Rezoning Transportation Analysis
Petition Number: Insert Zoning Petition #2021-042
General Location Identifier: 14125107 & 14125108

Revision Log:	Date	Description
	04/29/2021	First Review (KP)

Transportation Summary

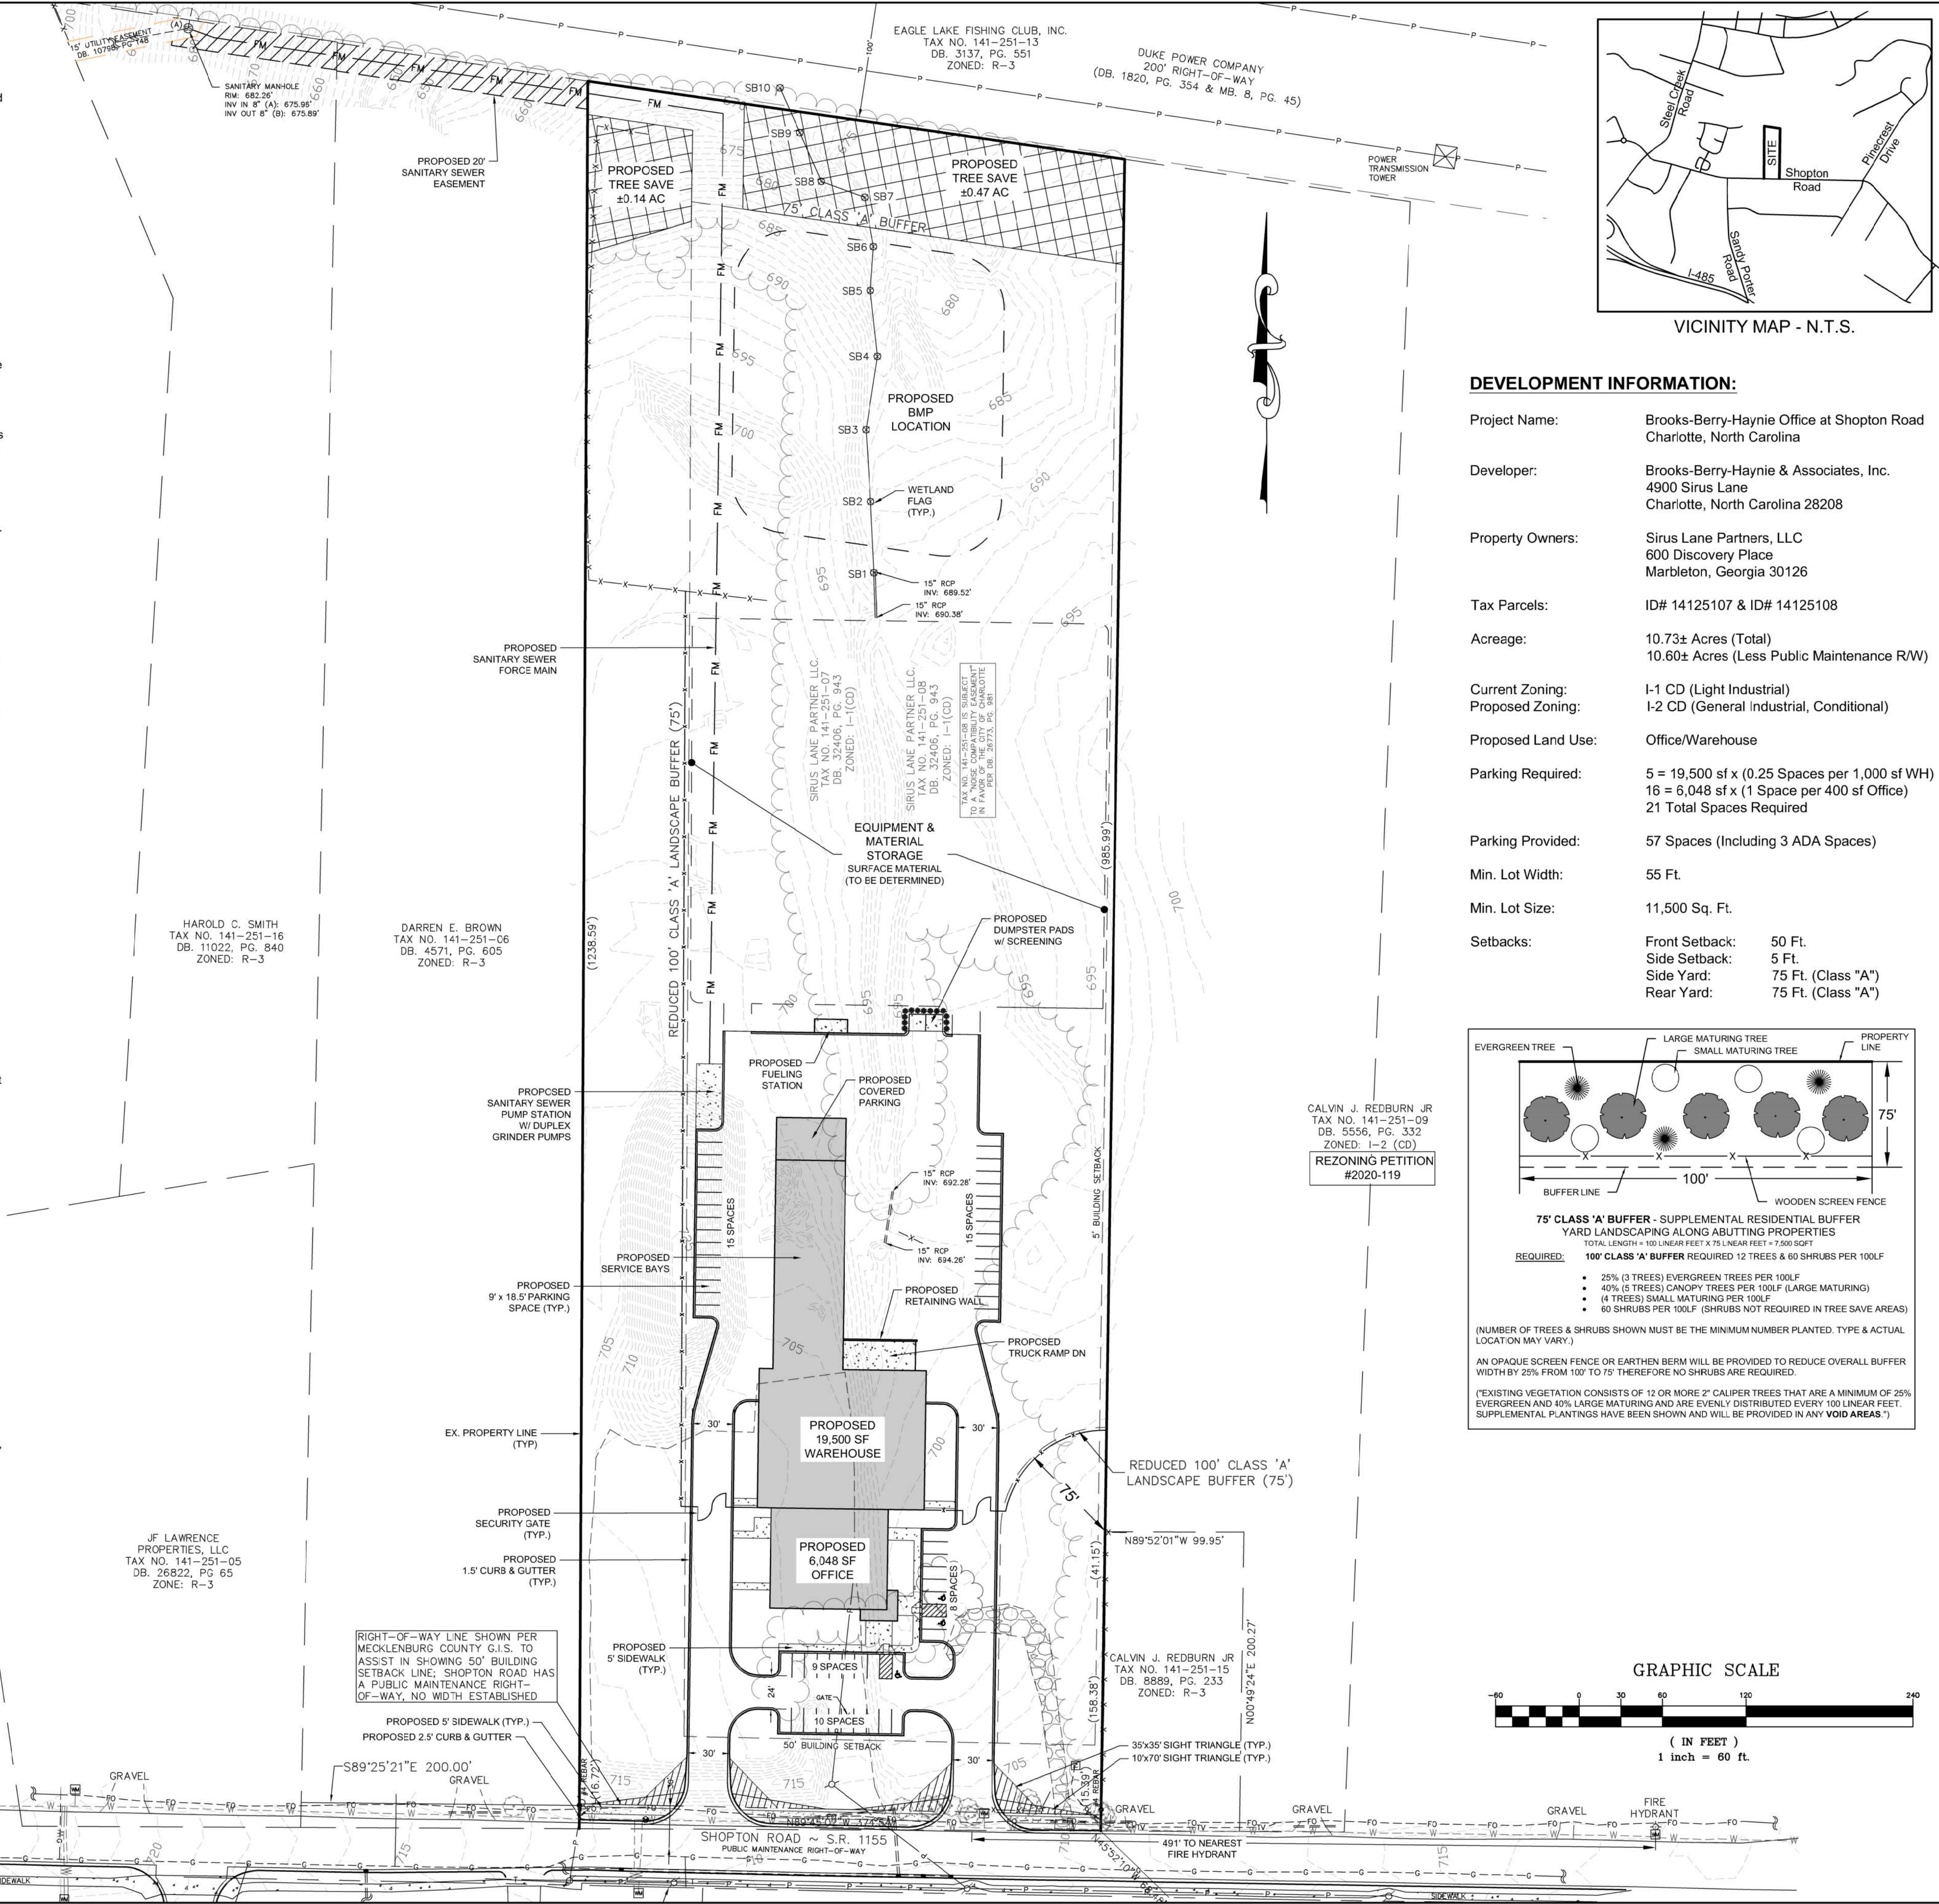
1. **Curb Line** - Shopton Road: The future location of curb and gutter is located 27-feet from the centerline to back of curb.

Label and dimension the curb and gutter from the existing road centerline road.

3. Revise site plan and conditional note(s) to commit to dedicate 43-foot right-of-way from the existing Shopton Road centerline. The site plan shall label and dimension the right-of-way from the road centerline.

4. Revise site plan and conditional note(s) to commit to construct an 8-foot planting strip, and 6-foot sidewalk on Shopton Road per Chapter 19. The site plan shall label and dimension both items from the back of curb and gutter and road centerline.

5. Revise the site plan and conditional note(s) to commit to construct a 5-foot bicycle lane with a 3-foot buffer along Shopton Road. Label and dimension from the Shopton Road centerline.

6. Revise the site plan by removing the site's west access driveway off of Shopton Road.

7. Revise the site plan and conditional note(s) to commit to re-striping the existing striped median to encompass an eastbound left turn lane with 150-feet of storage and appropriate bay taper. This striping will follow NCDOT Roadway Marking Standards. Include the striping on the site plan.

8. Revise the site plan and conditional notes to commit to connecting the bicycle and pedestrian infrastructure, as well as the center-left turn lane striping, into the previously approved infrastructure and striping associated with RZP 2020-119 adjacent to this petition. The infrastructure and striping will be designed and constructed in accordance with CDOT and NCDOT standards.
 Note: It will be beneficial to coordinate with 2020-119 as soon as possible to mitigate any unnecessary/redundant striping associated with the center-left turn lane.
